KITTITAS COUNTY COMMUNITY DEVELOPMENT SERVICES

Subject: Palomino Fields Div 2 (LPF-19-00003) Final Long Plat – Return to Applicant, Second Review, Additional Information Required.

LP - 19-00003

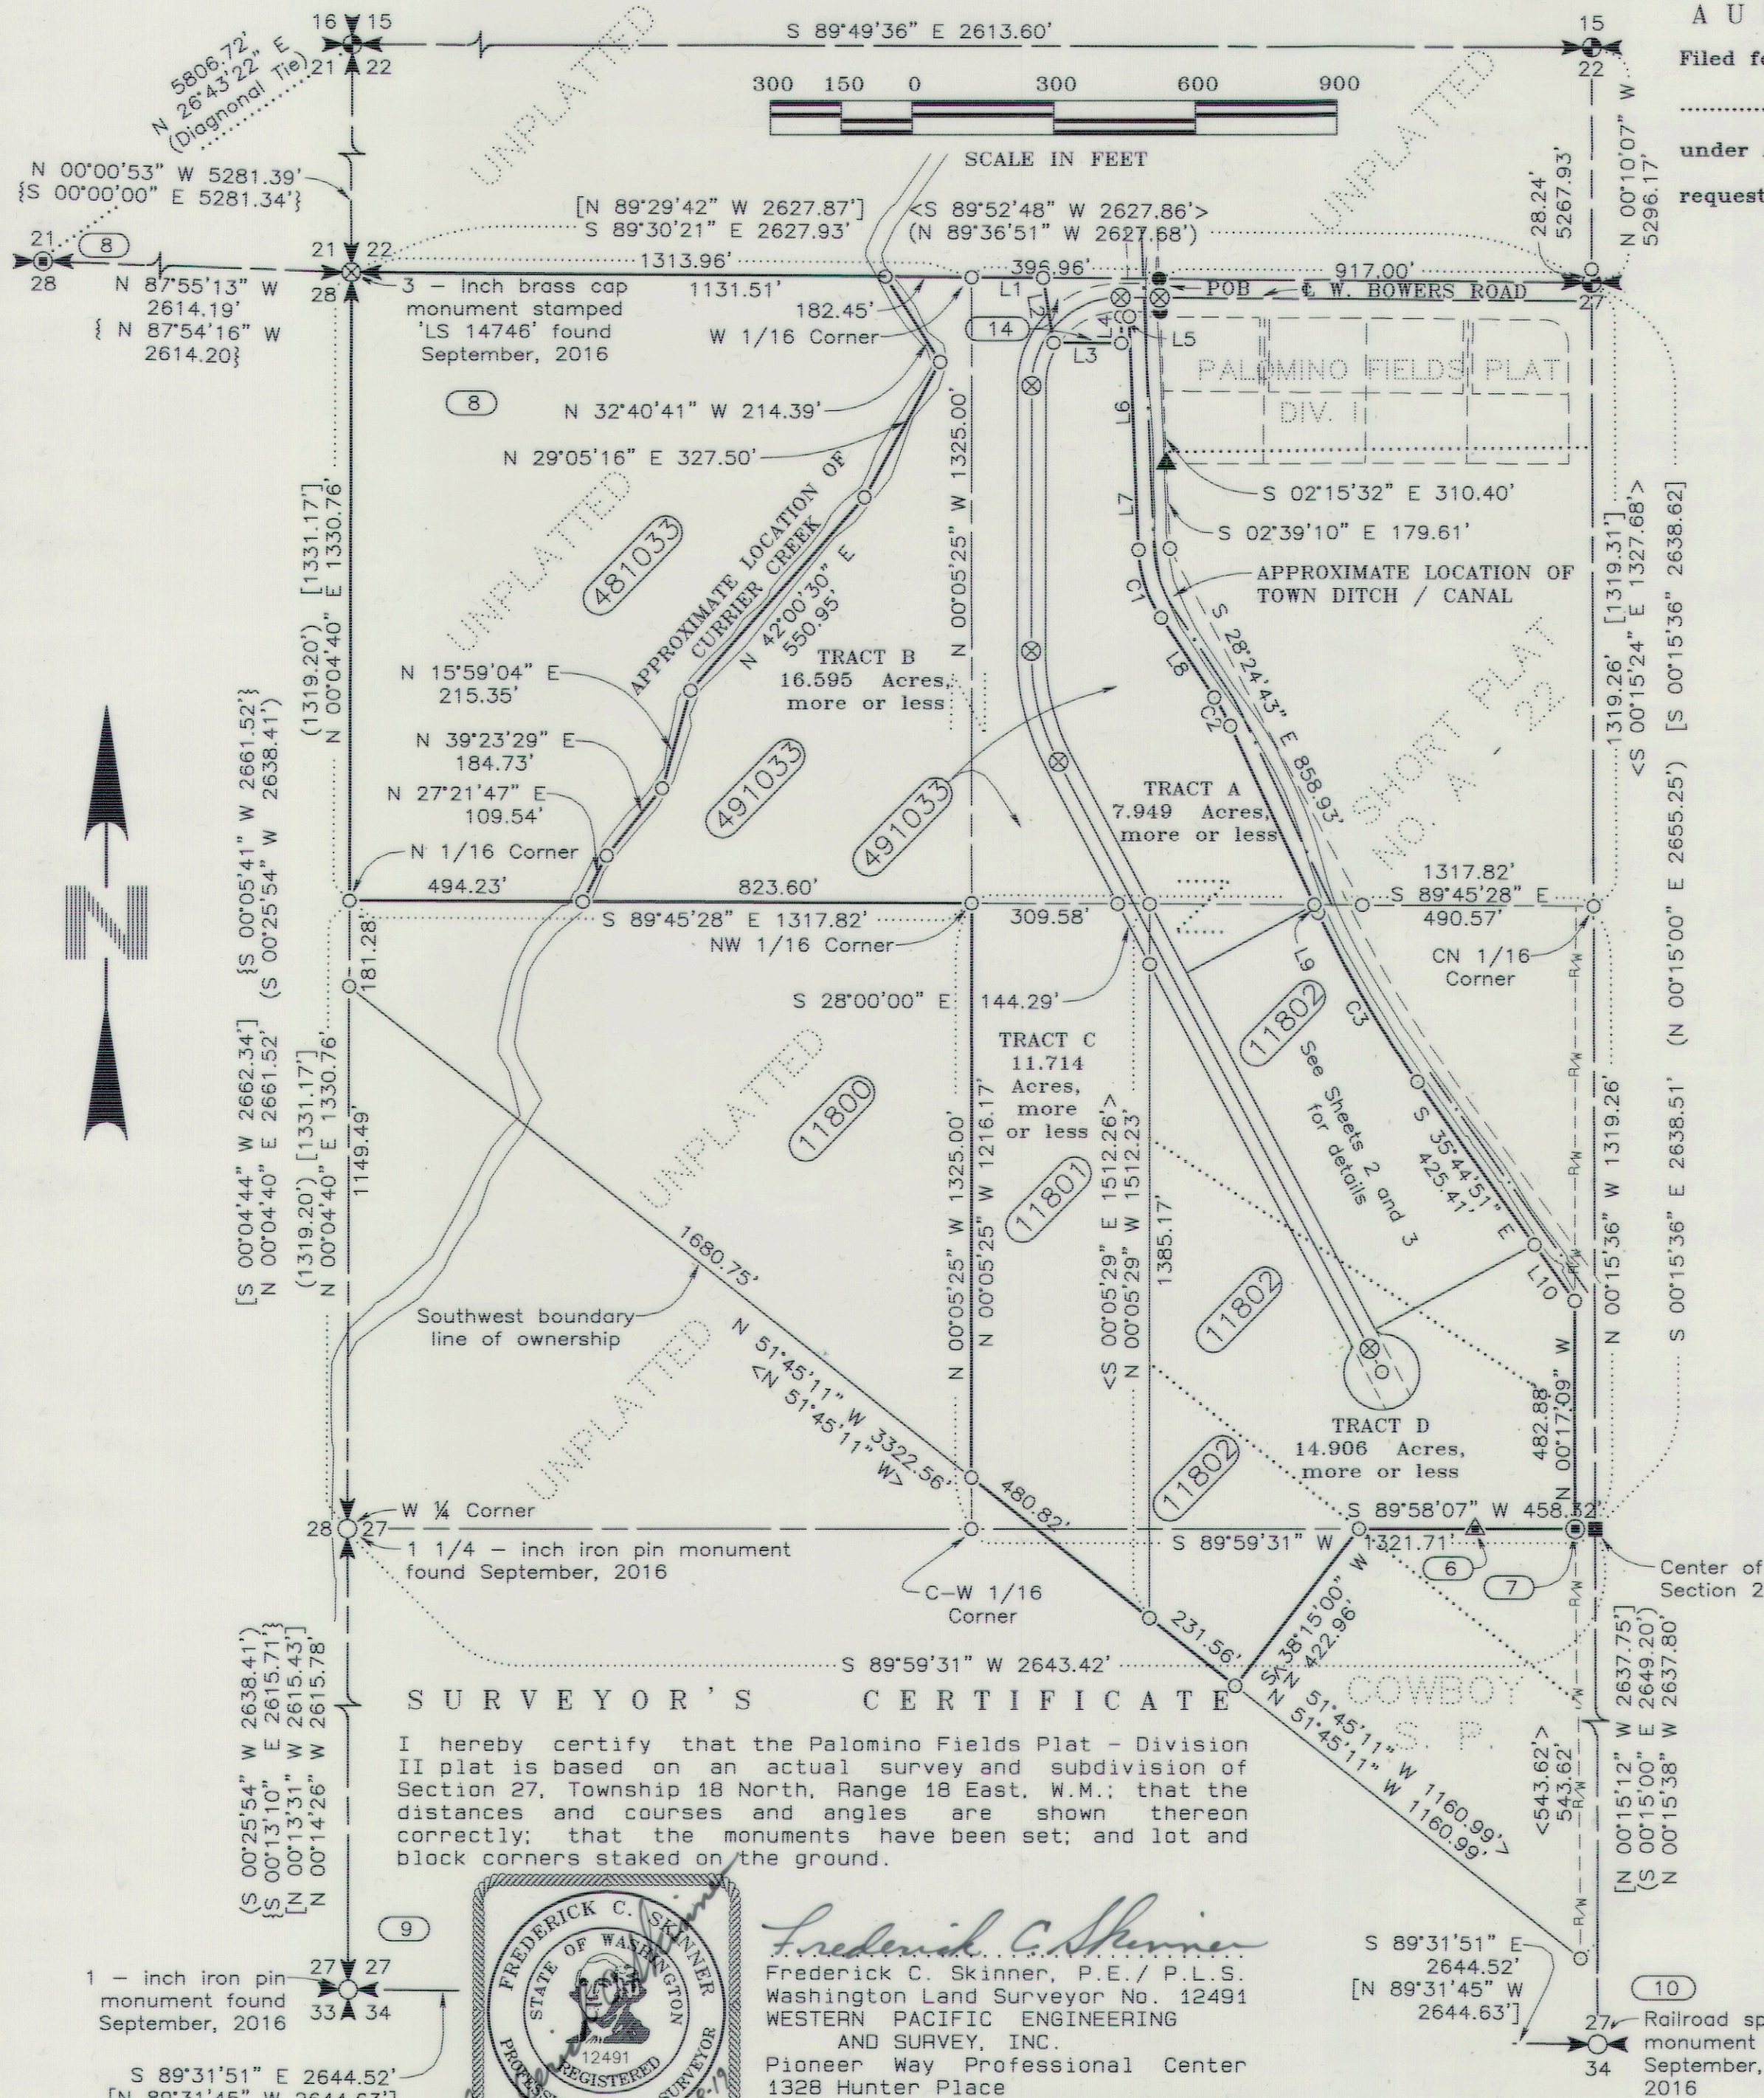
On April 22, 2019 CDS received your final mylar submission that included changes based on the first round of County review. The final mylars were routed to Kittitas County Public Works for a final review. Pursuant to the comments provided by Kittitas County Public Works on April 25, 2019 (see attached) this final plat submittal has not met all of the necessary requirements for final plat approval. RCW 58.17.140 states, "Final plats and short plats shall be approved, disapproved, or returned to the applicant within thirty days from the date of filing." CDS is returning your application to allow an opportunity for the application materials to address all preliminary plat conditions and review comments/requirements. In addition to the comments from Kittitas County Public Works, the file number provided on the face of the plat reads "LP-19-00003". This should read "LPF-19-00003" and "LP-07-00031".
